REQUEST

Approximately 45.67 acres located on the west side of South Tryon Street, north side of Clanton Road, and east side of Interstate 77.

SUMMARY OF PETITION

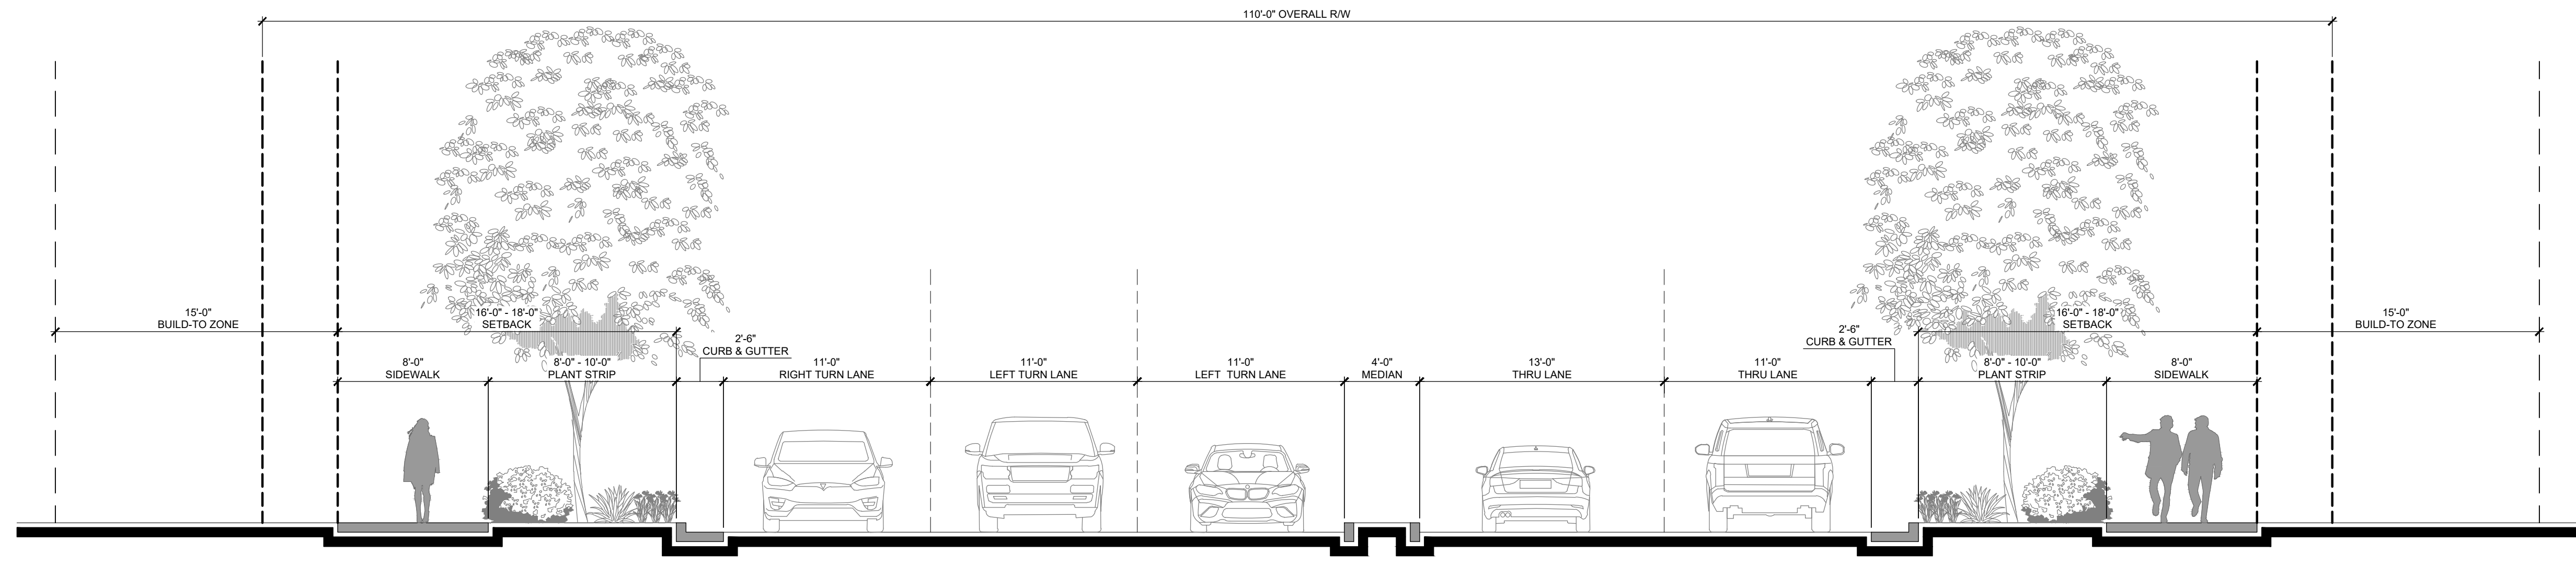
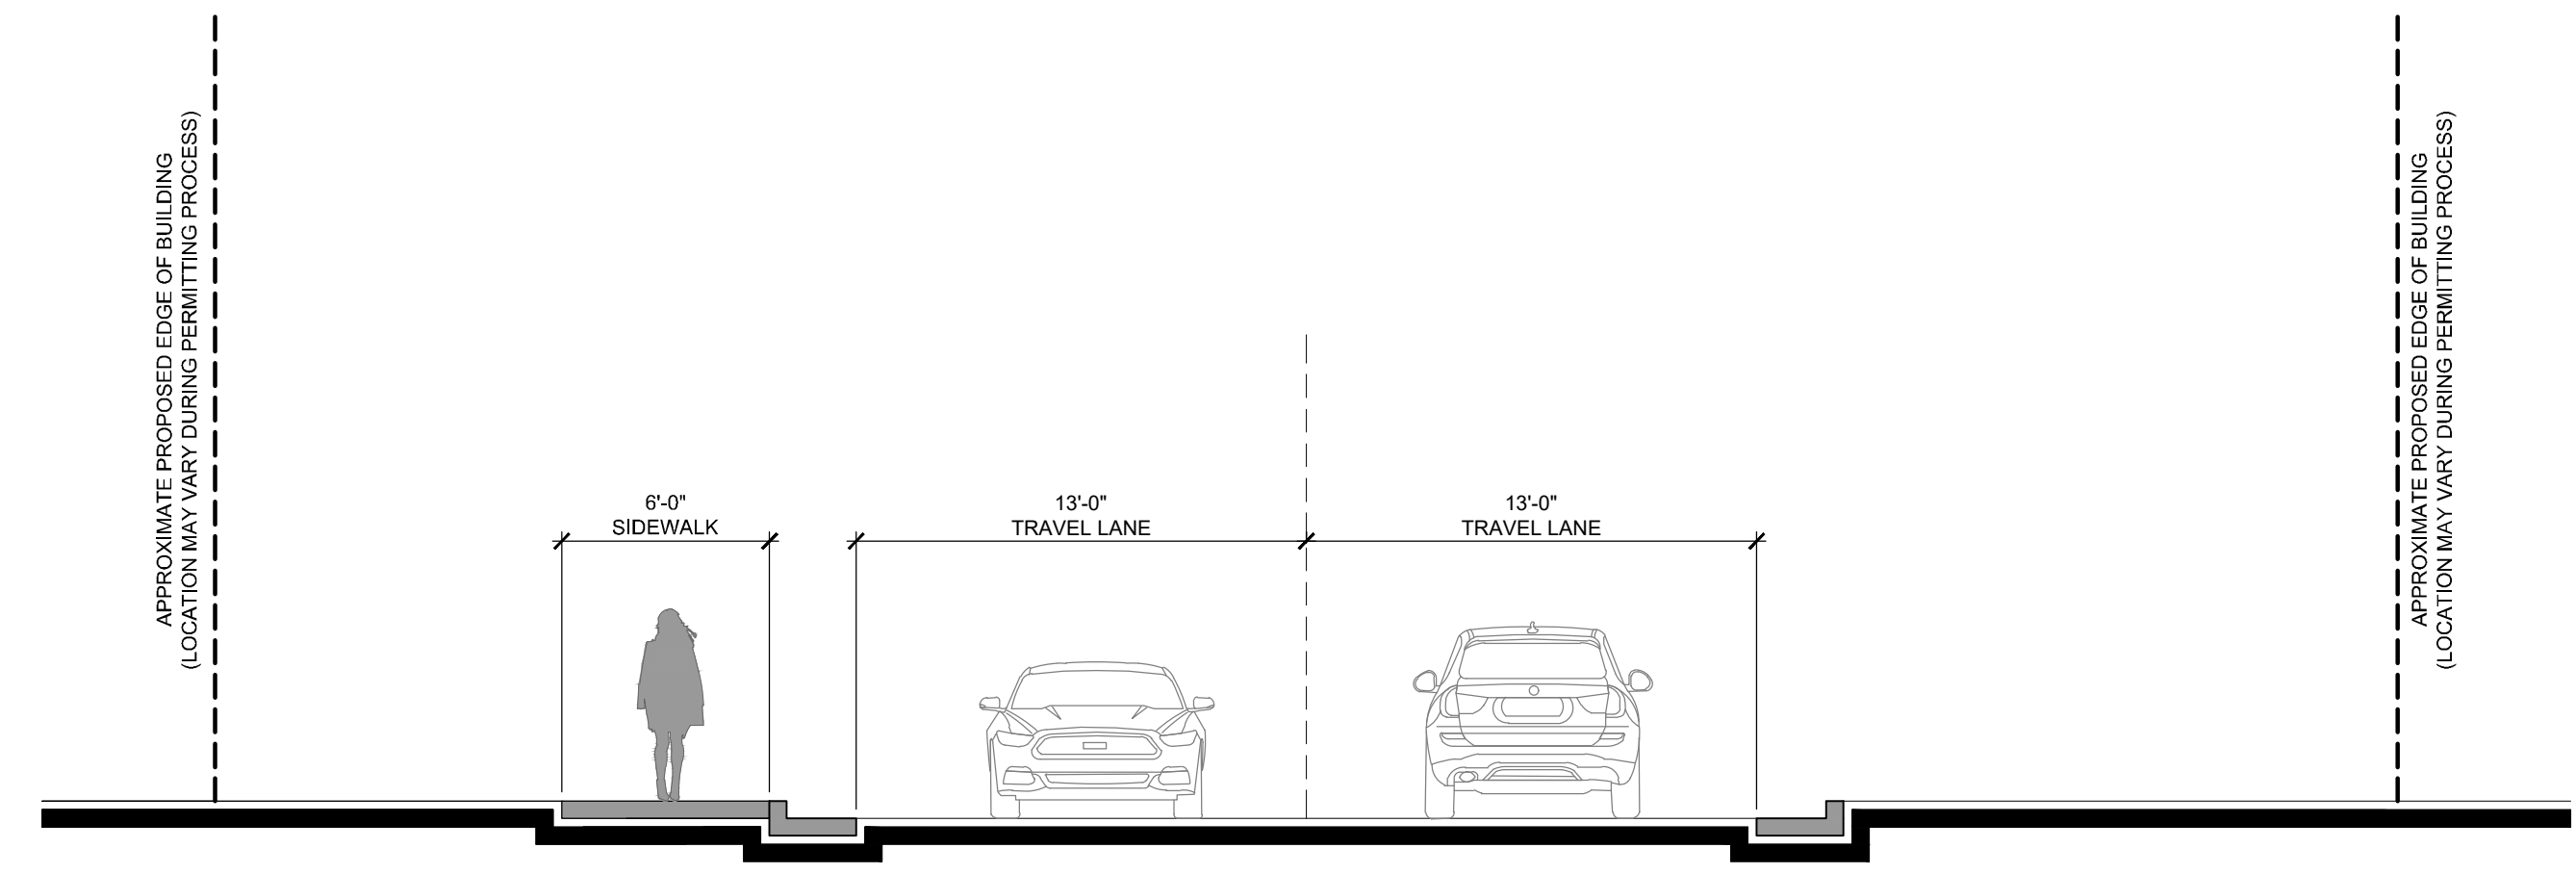
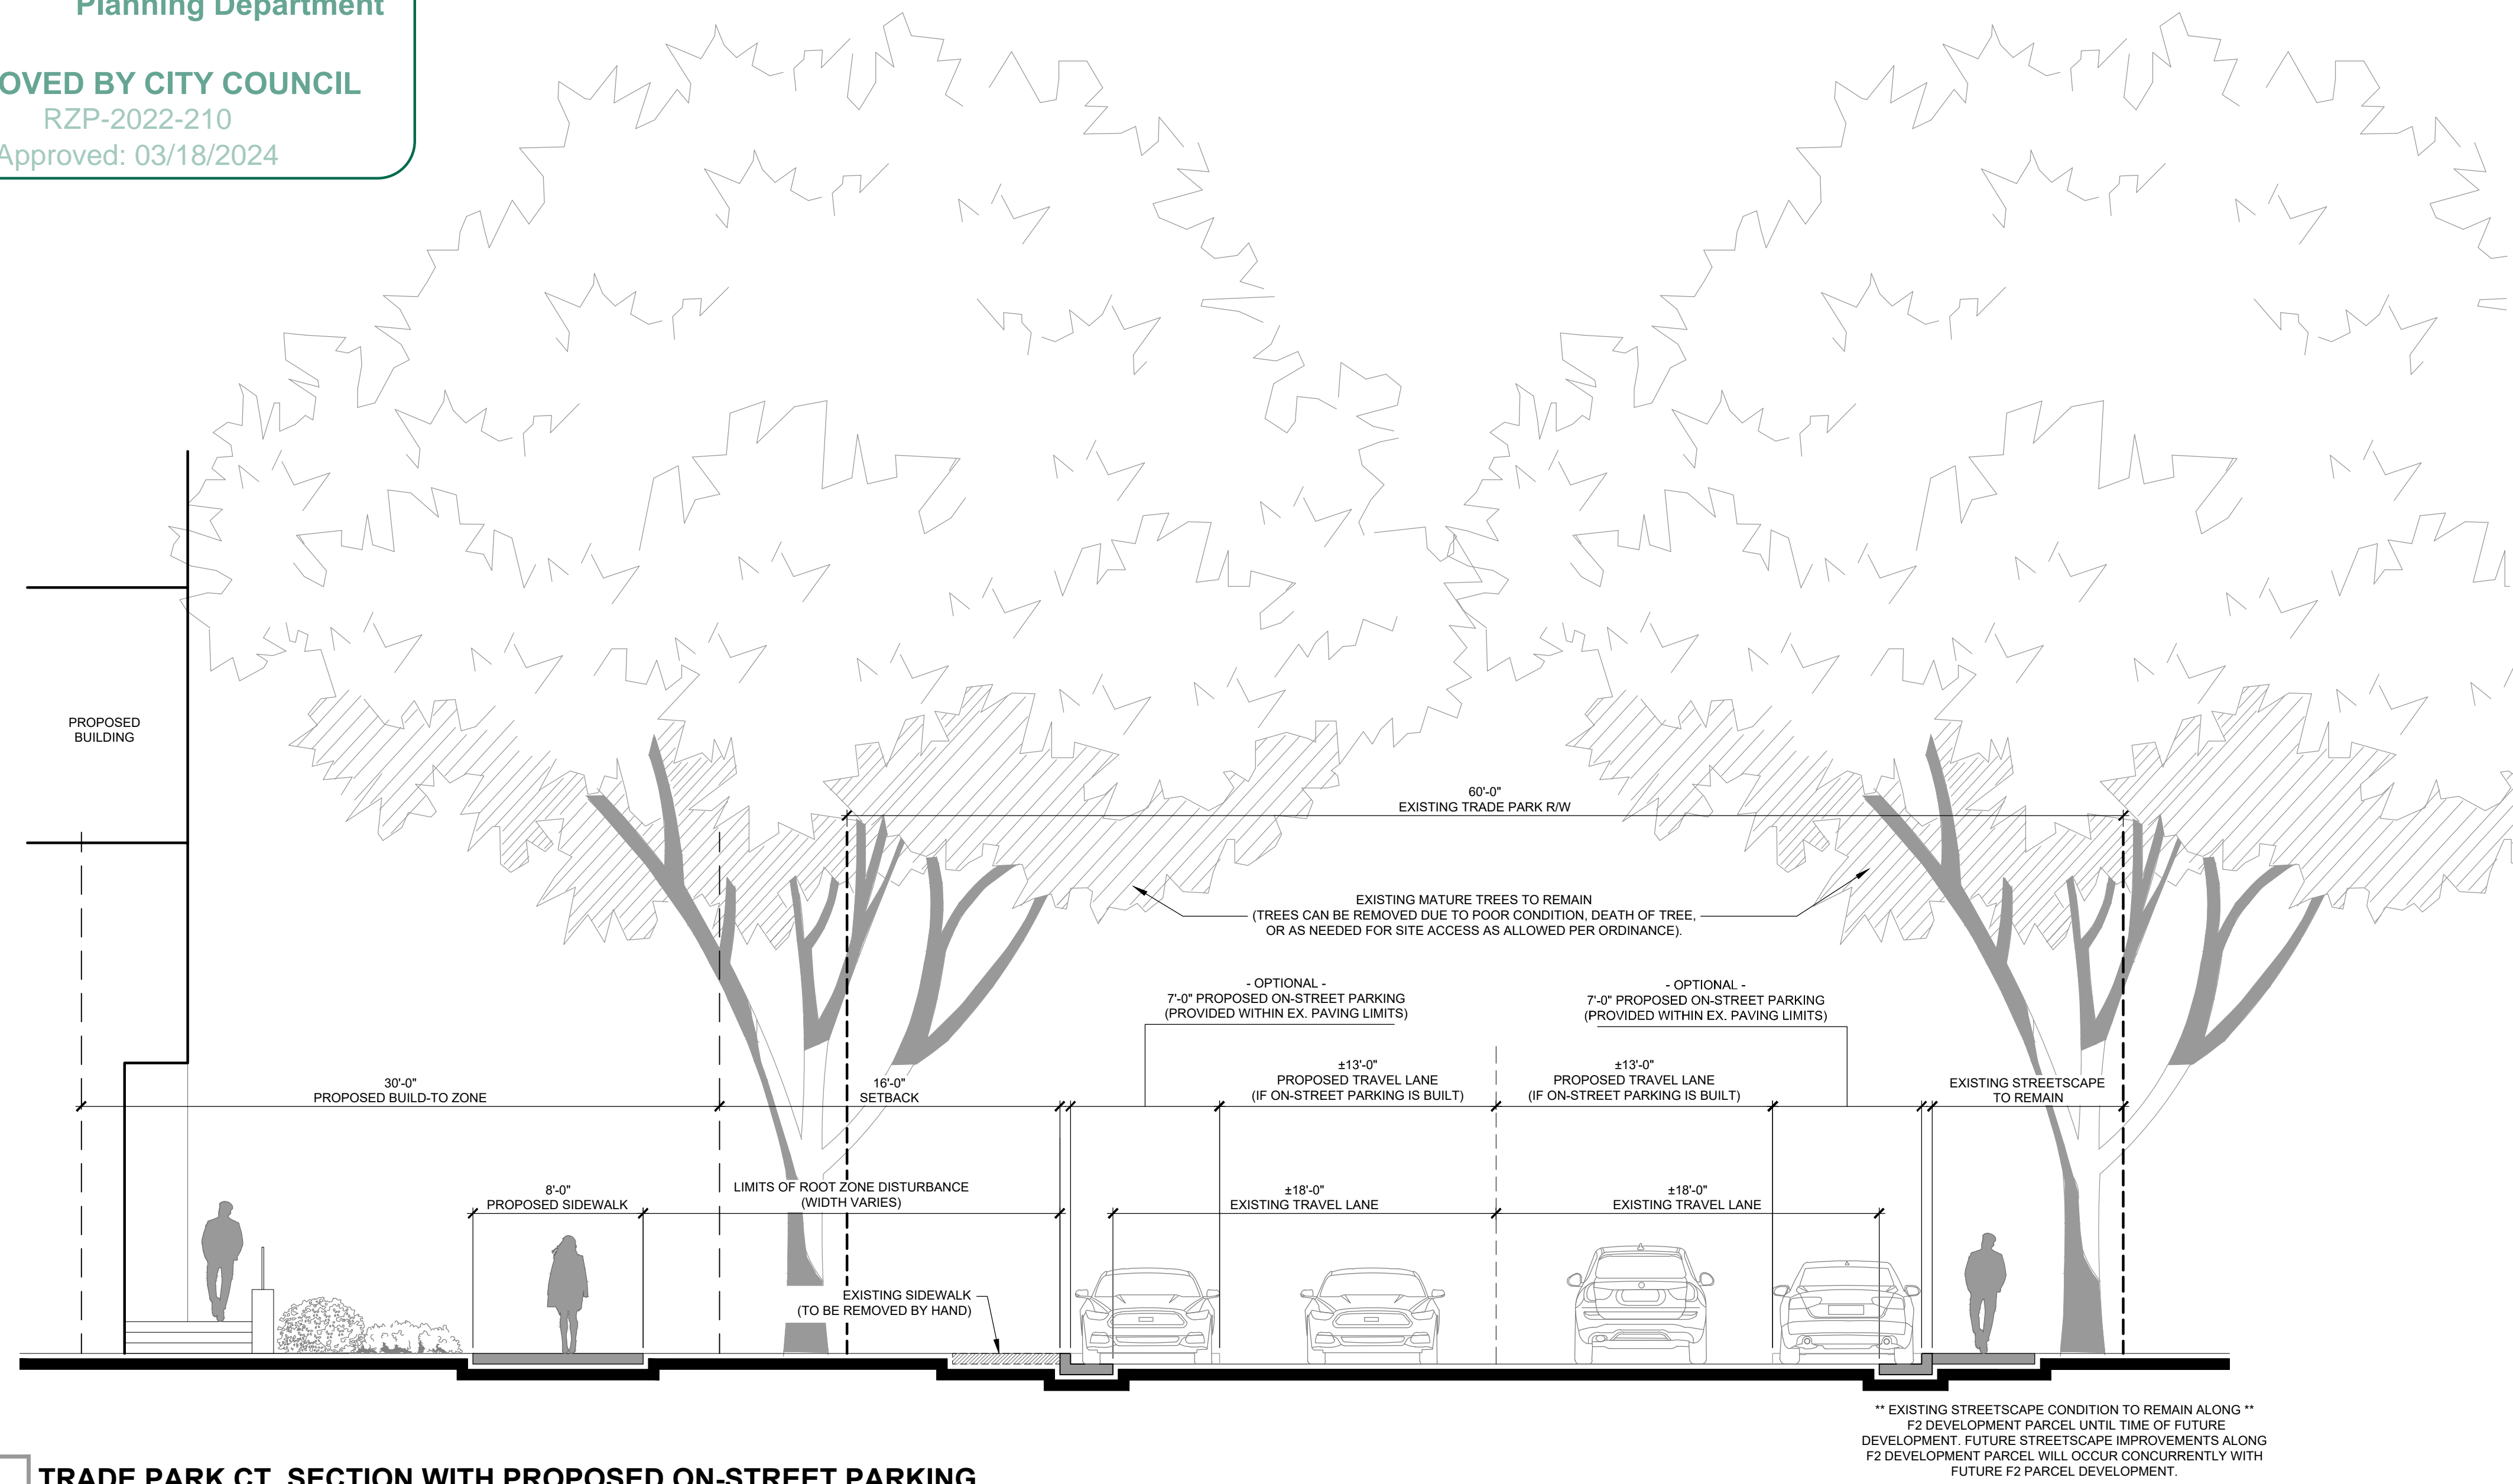
7. ~~Revise the design standard notes for drive-throughs so that no drive aisle may be located between the building façade and the street, menu boards may not be visible from the street, and note that seat walls that meet screening requirements will be provided to enhance the pedestrian environment.~~

Addressed

- Allow modifications to the required public and network required street cross sections between Trade Park Court from Tryon to the end of the existing cul-de-sac, and St. Vardell from Clanton to Public Street B. On-street parking may be eliminated on one side of the street for up to 50% of the block frontage.
